Transport
for NSW

Moriah College Redevelopment (SSD 10352)

The Environmental Impact Statement and the associated Transport Impact Assessment have been reviewed. It is noted that the proposal seeks approval for concept development of the southern portion of the campus and the stage of building works that include staged demolition of existing buildings and construction of a new building with associated amenities. Comments are provided in the attached **TAB A** for consideration.

PROJECT	MORIAH COLLEGE
TITLE	SWEPT PATH ANALYSIS AS2890.2 12.5m HEAVY RIGID VEHICLE - GATE 3A - BARONGA AVENUE

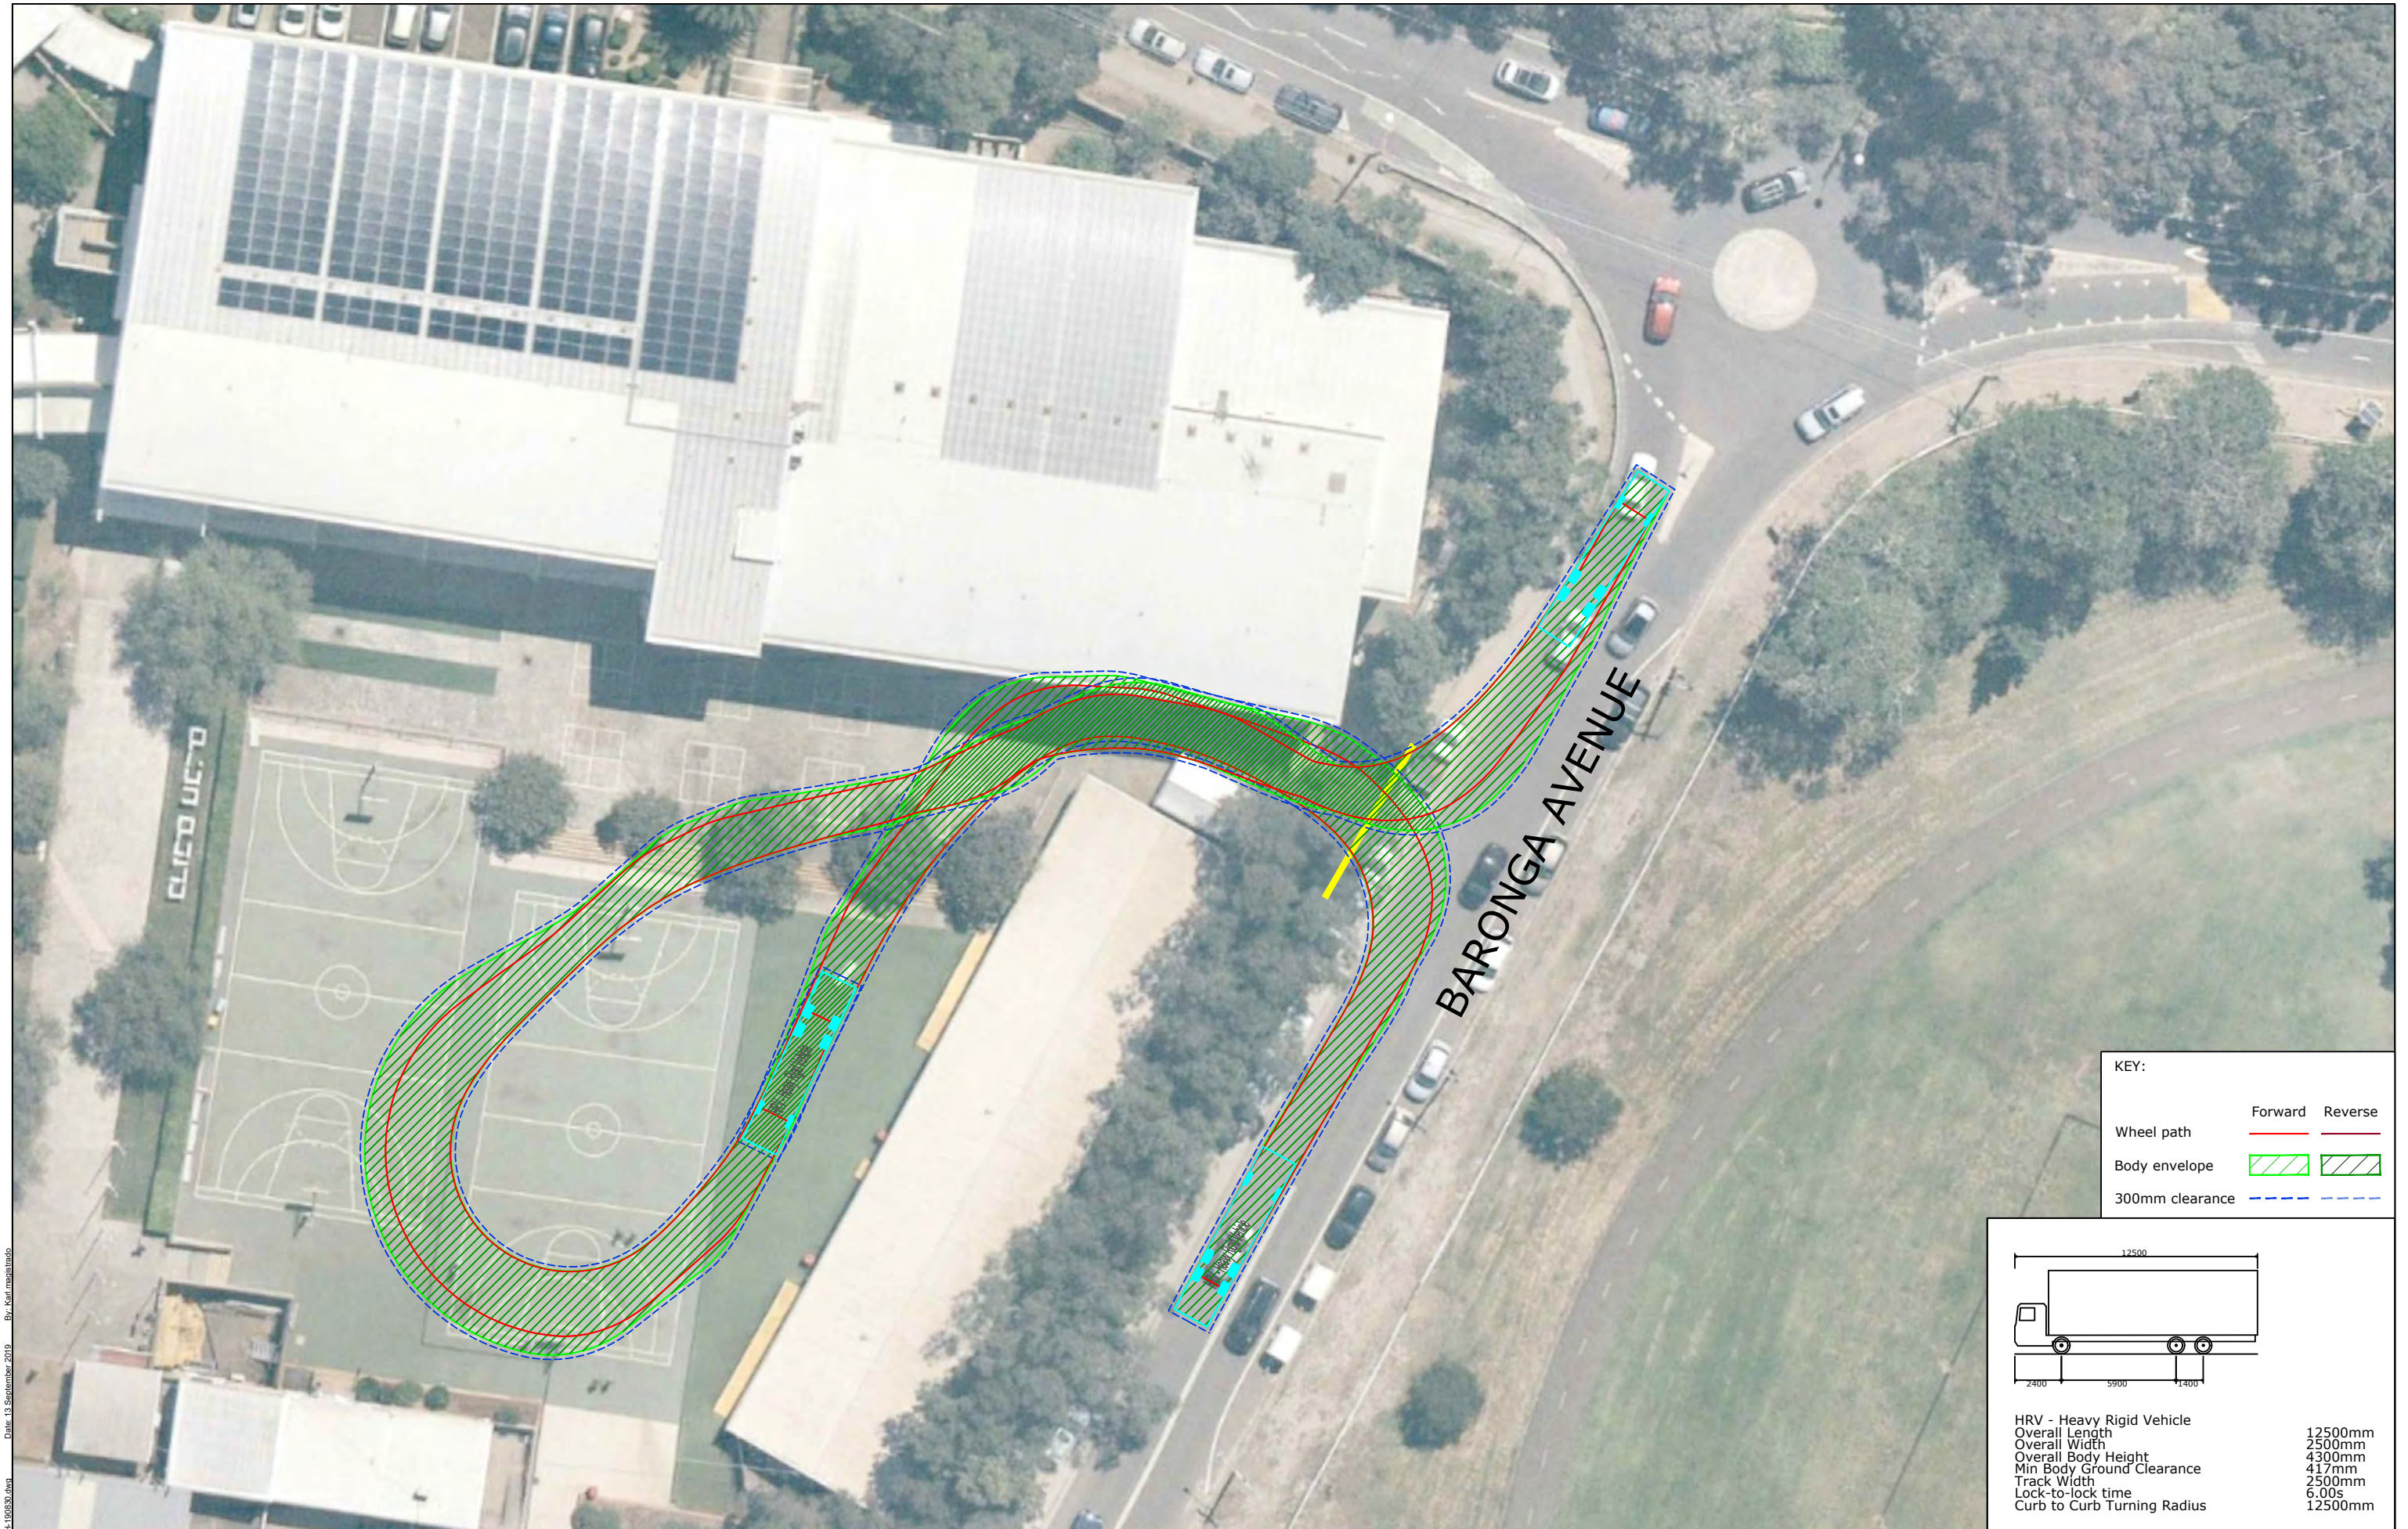
A Preliminary Construction Traffic and Pedestrian Management Plan (CTPMP) has been prepared in support of the proposal. The preliminary CTPMP indicates the two construction site access gates will be located on Baronga Avenue and York Road. Truck movements should not be carried out during school pick up and set down times (unless otherwise approved) and no truck queuing should be permitted on public streets that would affect the general traffic and public transport operation.

A detailed Construction Pedestrian and Traffic Management Plan for various stages detailing construction vehicle routes, number of trucks, hours of operation, access arrangements and traffic control should be submitted to the relevant consent authority for approval prior to the issue of a Construction Certificate.
